**Consultation Response from KC,
Trees**
2021/91239 410/412, Birkby Road, Birkby, Huddersfield, HD2 2DN
Demolition of existing dwellings and garage and erection of two detached dwellings
Date Responded: 26/05/21
**Responding Officer: Nick
Goddard**
Responding Ref: TPO 14/75

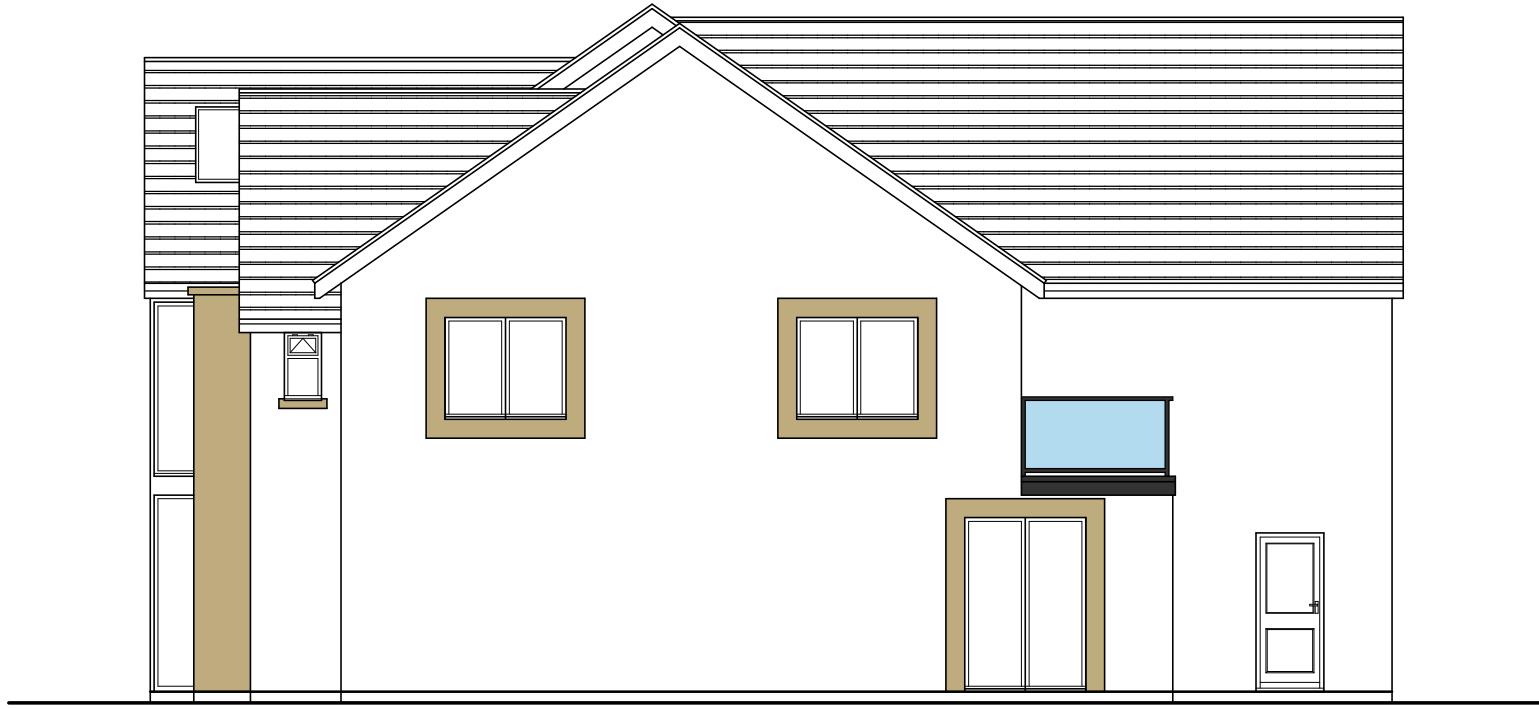
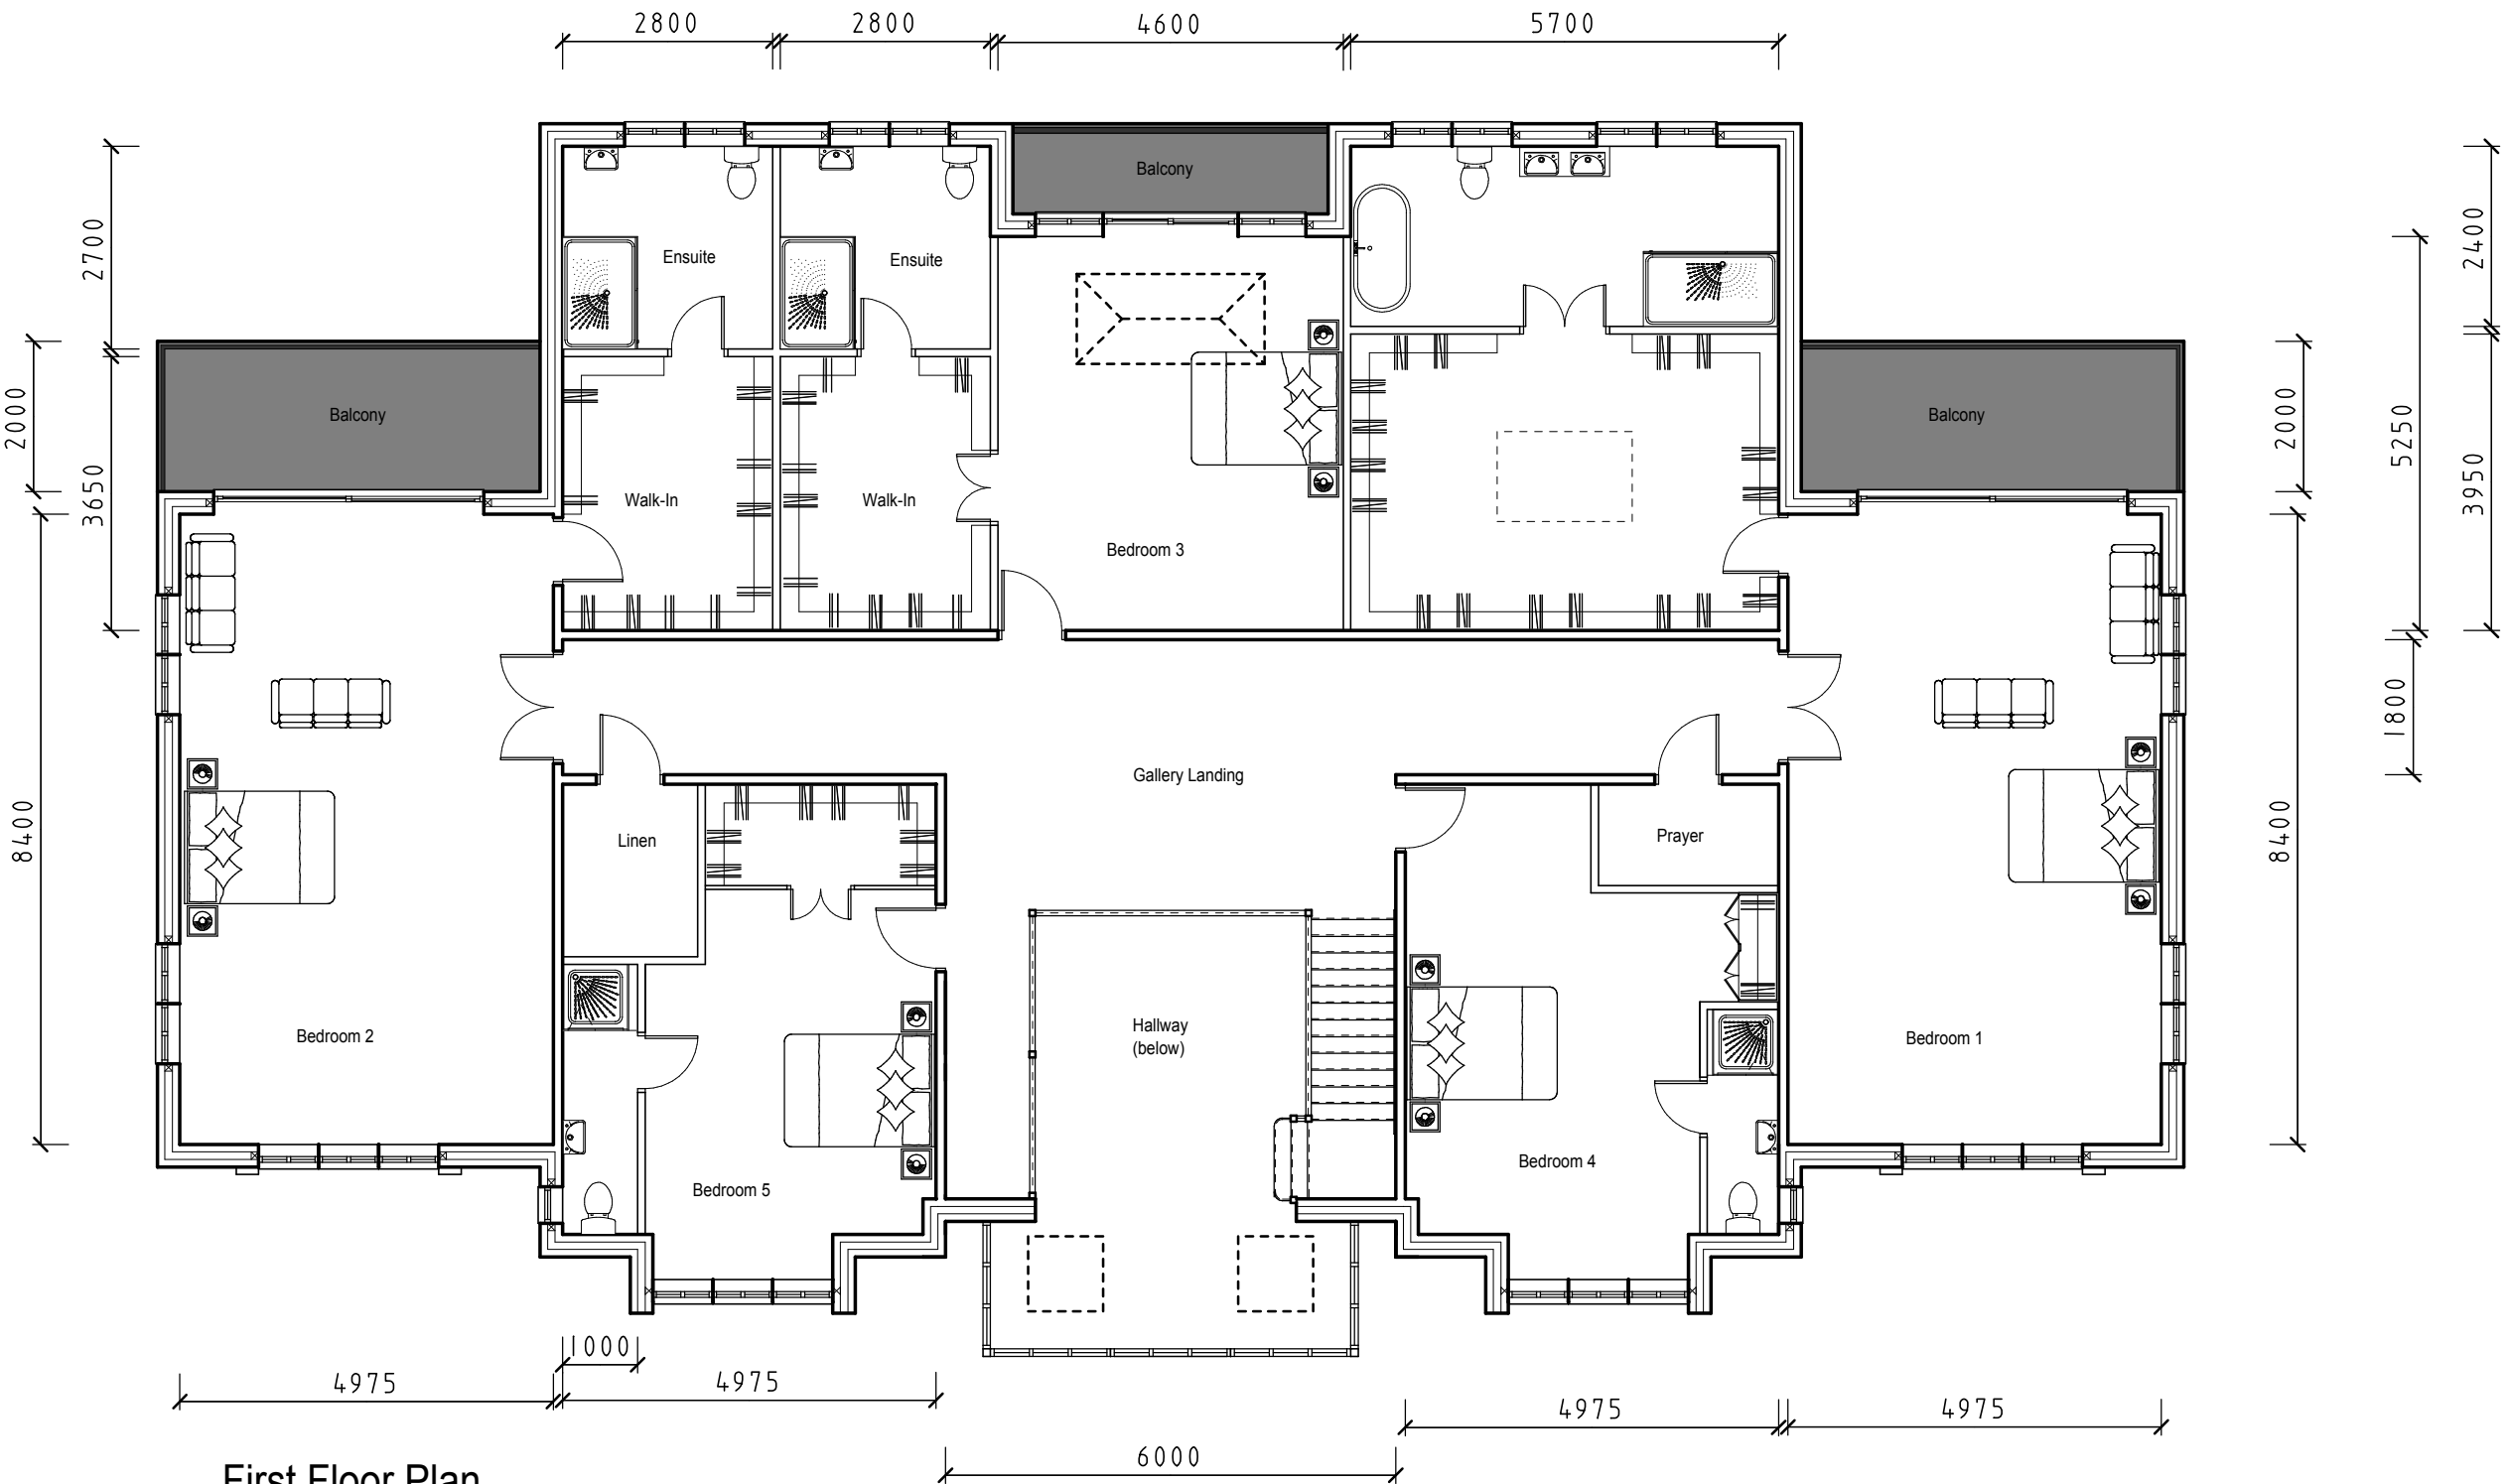
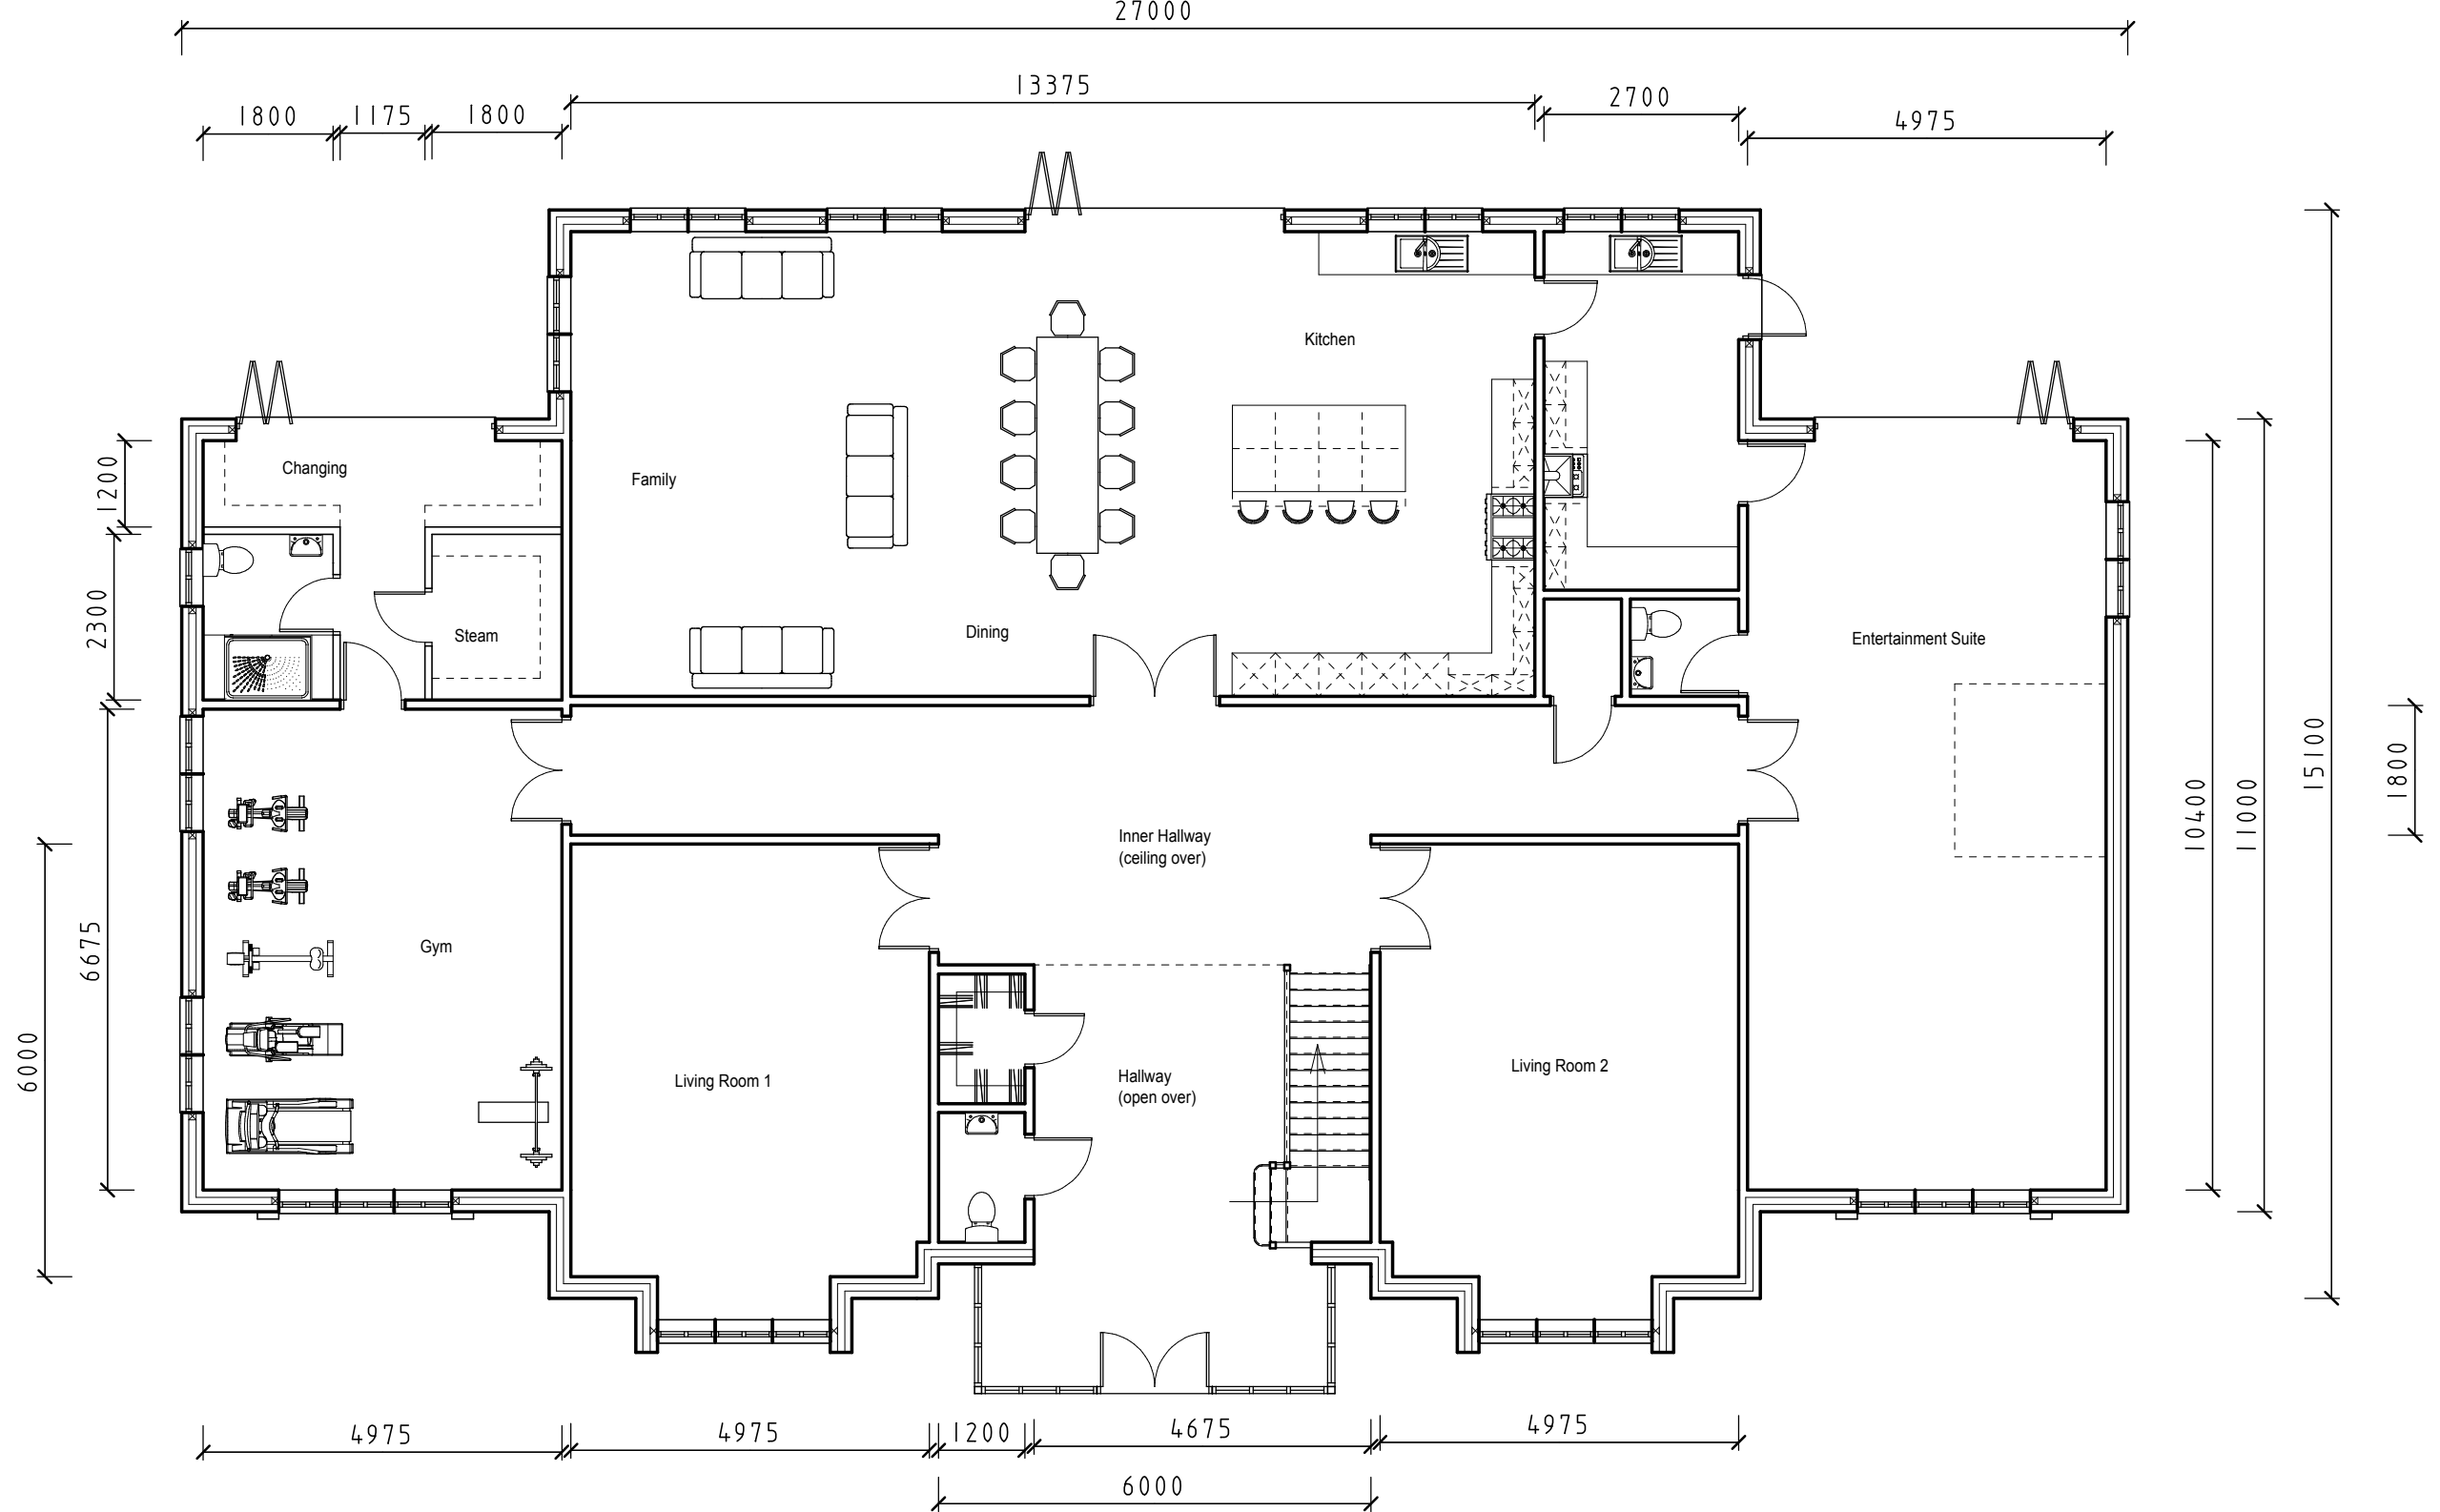
The tree information submitted is good quality, but I do have a few concerns with the assessment. BS5837 refers to 20% of the rooting area in relation to new surfacing constructed in a tree friendly manner such as to retain rooting area beneath new surface. It is not acceptable for the design of the properties to result in root protection area to be lost. The proposals will result in either excavations of the rooting area for a garage or the installation of a retaining structure and loss of roots as a result.

In summary, I have concerns about the eastern plot being too close to the trees adjacent. The ground level changes mean that a retaining structure is necessary on this eastern side, the construction of which causes yet more loss of rooting area. The garage on the western side is within the rooting area of a large mature tree and requires loss of rooting area which is also not acceptable.
